Application Ref:	2025/0340			 Ribble Valley Borough Council www.ribblevalley.gov.uk
Date Inspected:	Various.	Site Notice:	23/05/2025	
Officer:	EP			
DELEGATED ITEM FILE REPORT:				APPROVAL

Development Description:	Prior notification for enlargement of dwelling by construction of one additional storey.
Site Address/Location:	36 Painter Wood, Whalley Old Road, Billington BB7 9JD.

SHEET: PROPOSED ELEVATIONS

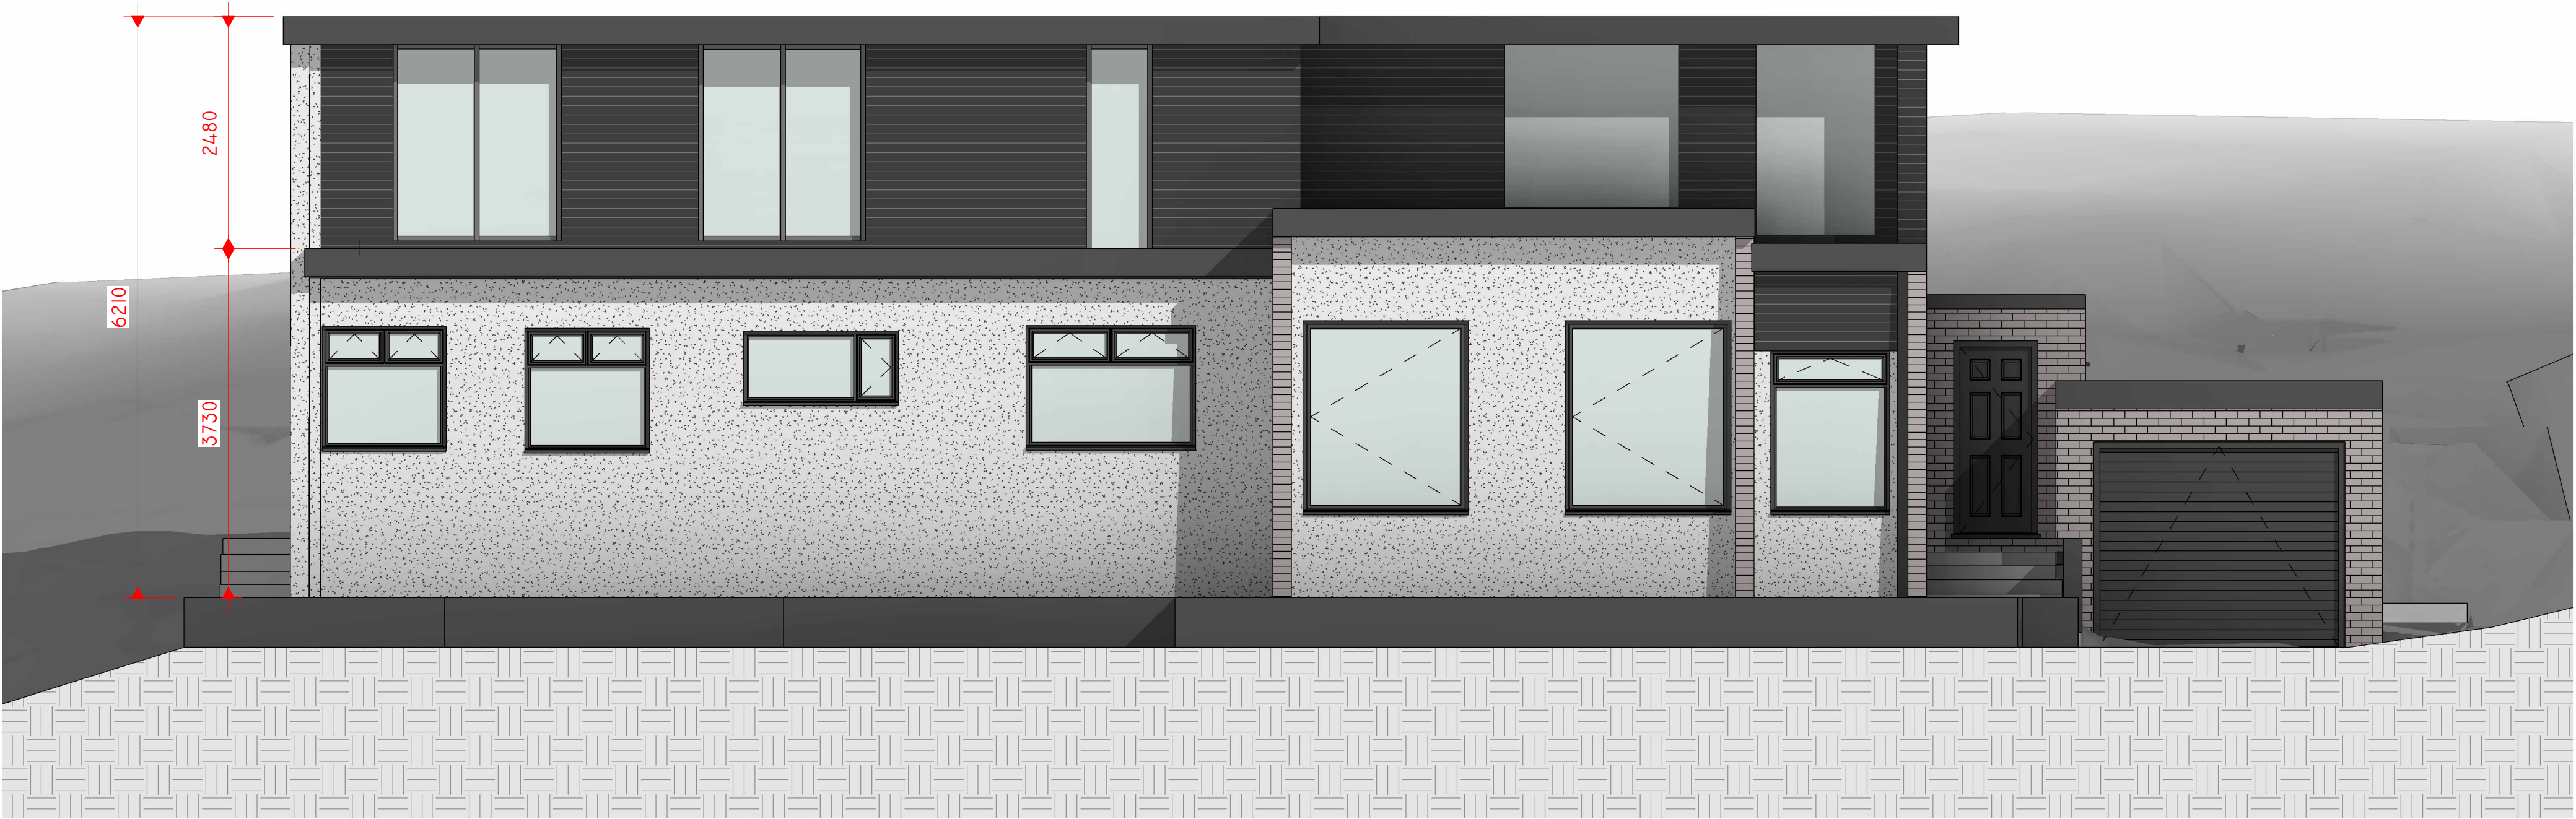
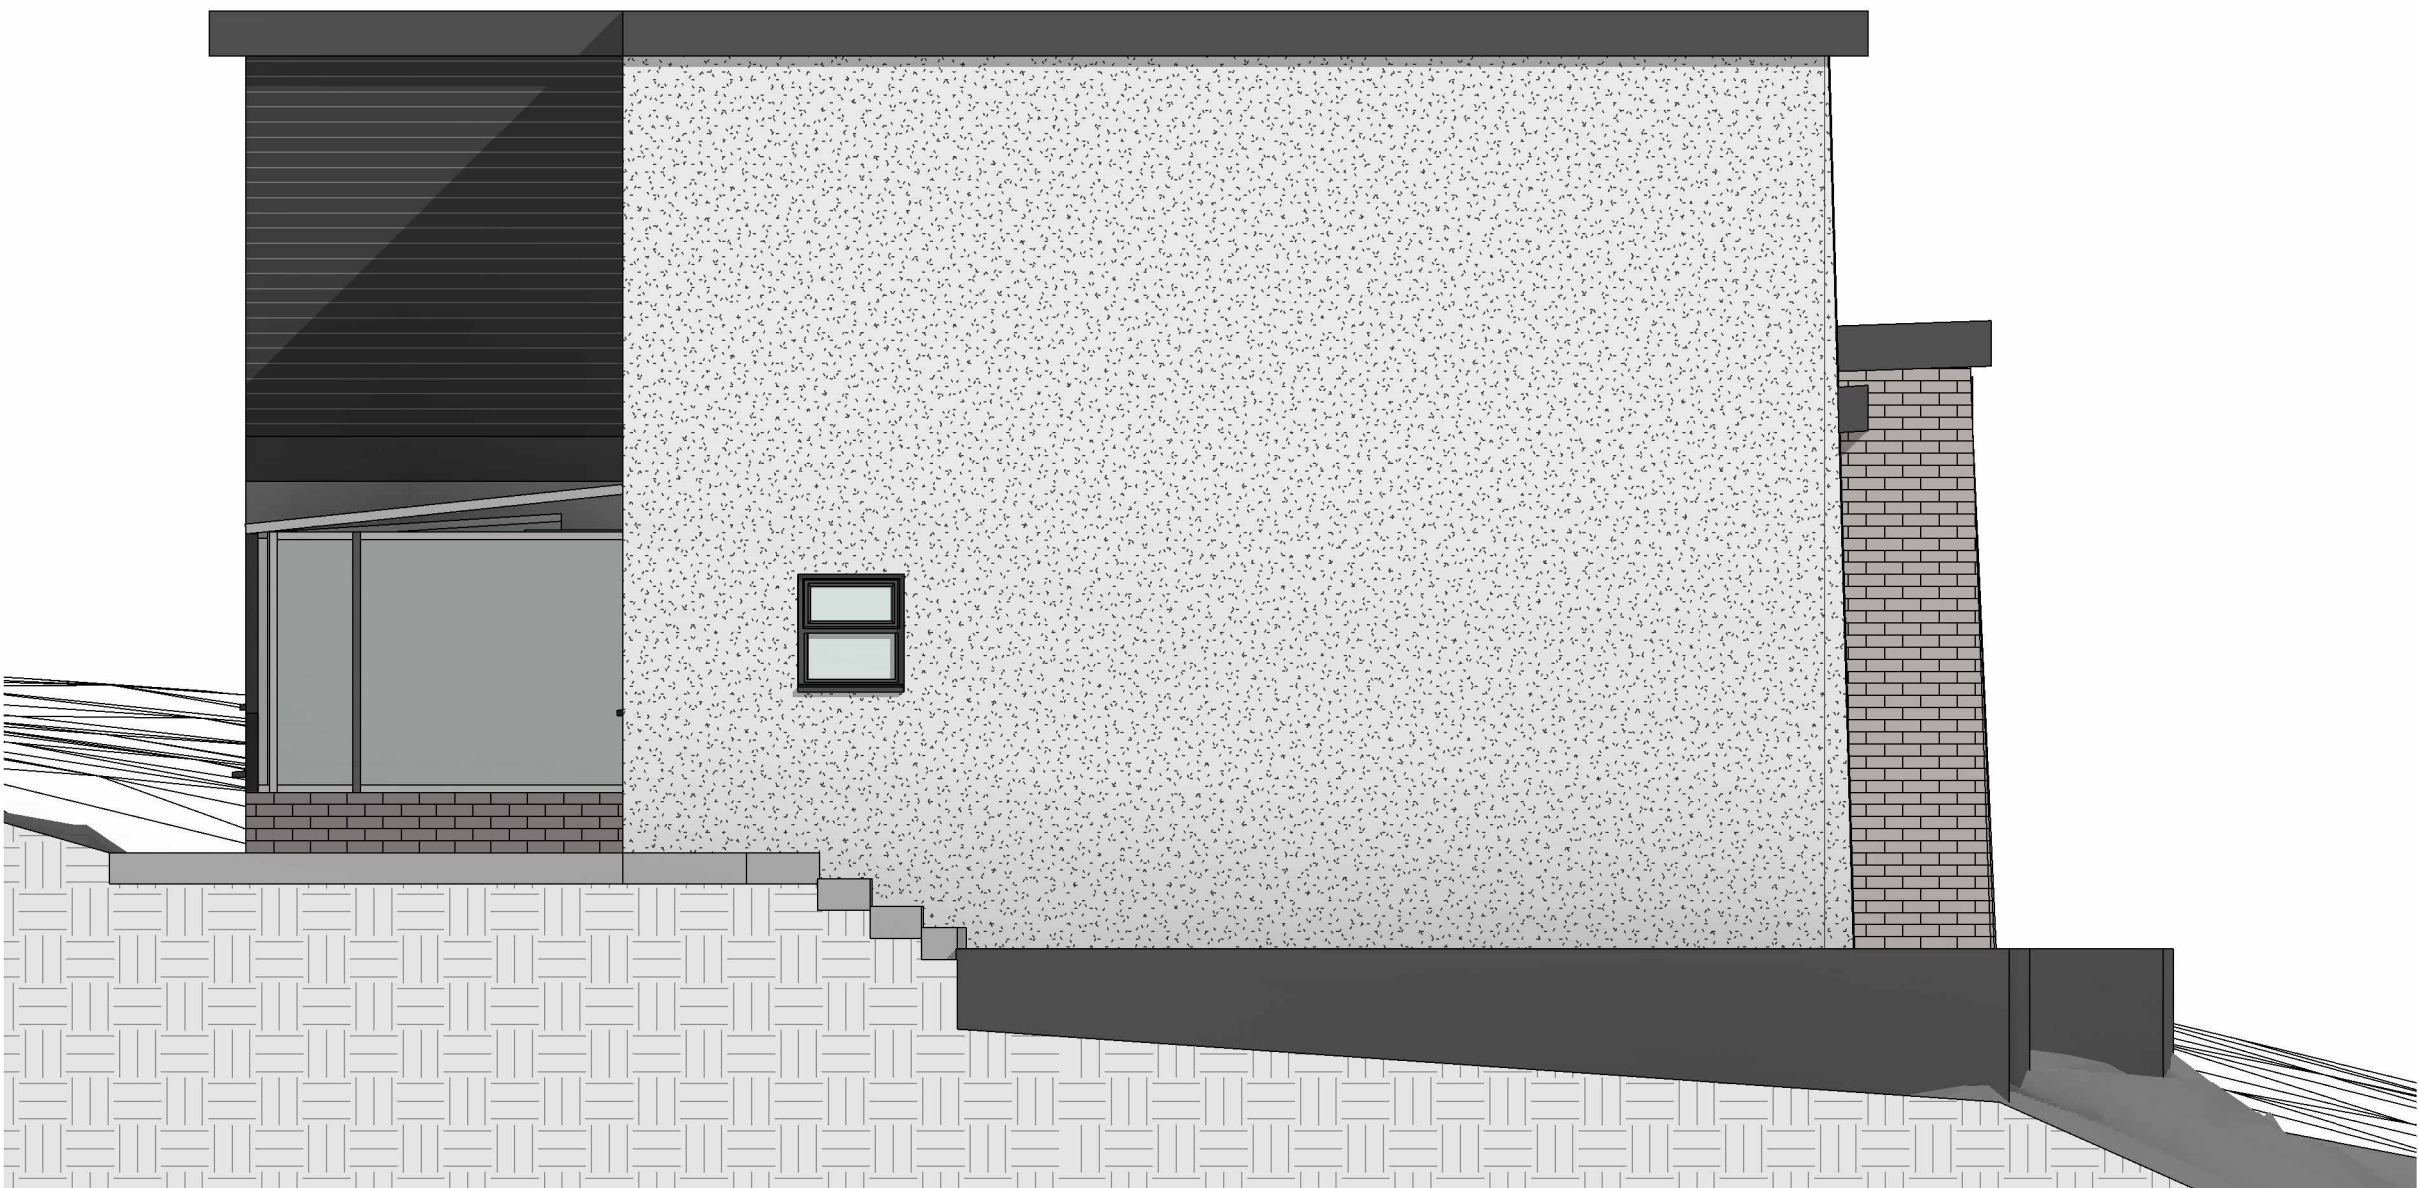
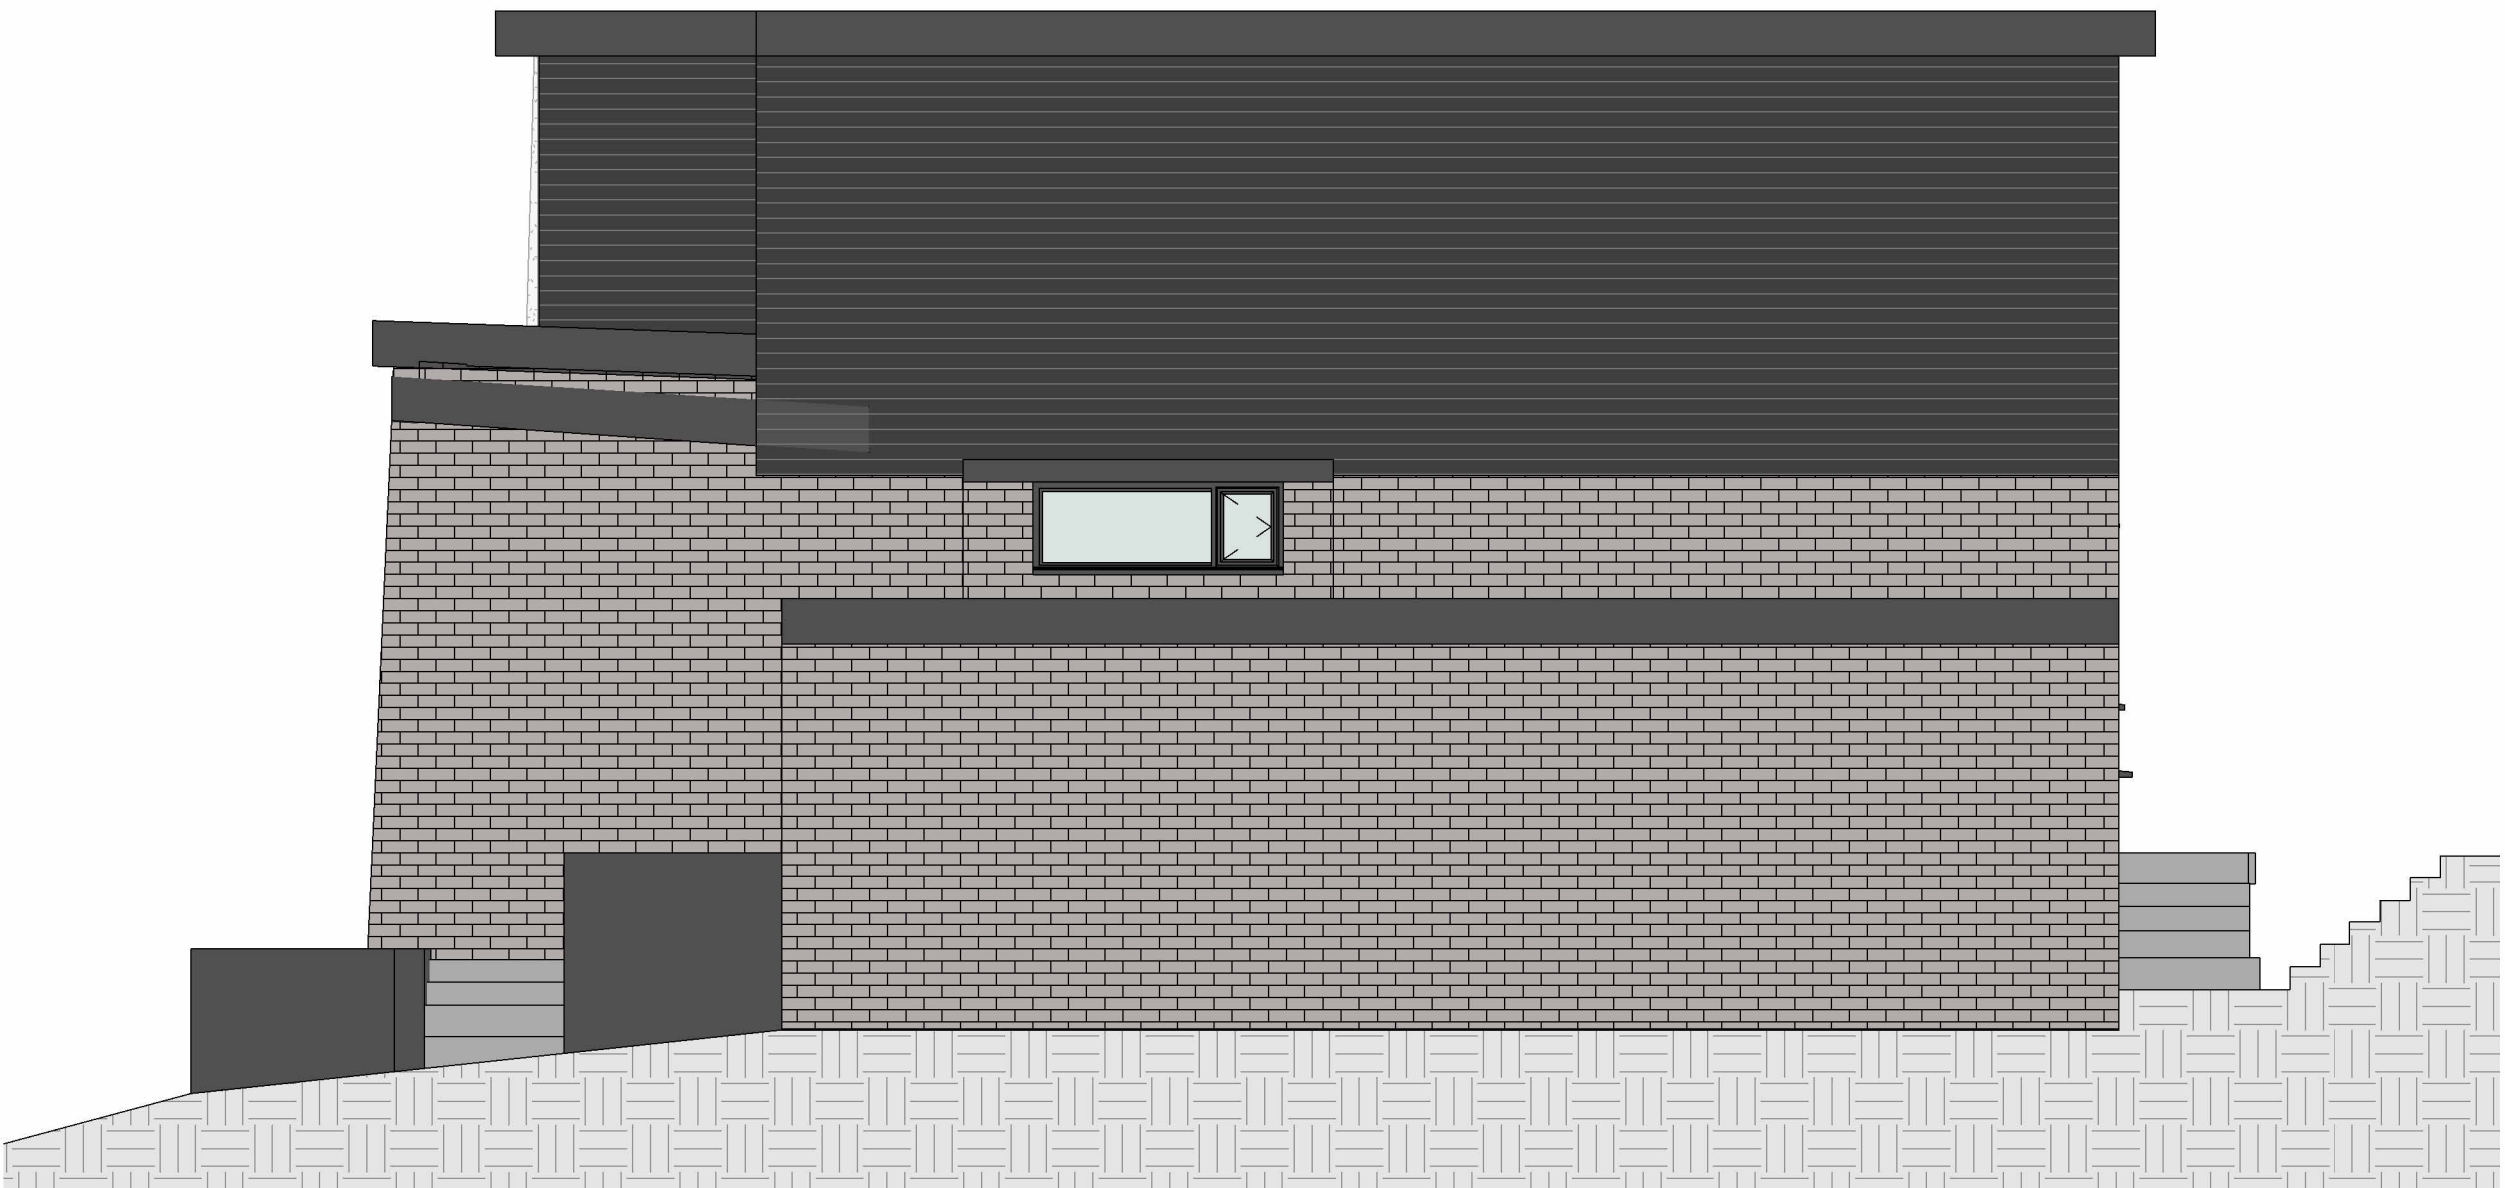
The floor to ceiling height of the additional storey will not exceed the height of the floor to ceiling height of the existing dwelling.

The principal elevation of the dwelling fronts Painter Wood and is therefore highly visible. The appearance will substantially change following the introduction of an additional storey. However, in respect of the proposed glazing and materials, the design and external appearance will remain largely consistent with the existing dwelling and neighbouring property to the Northeast. As such, it is not considered that the development will be of significant harm to the visual amenities of the area.
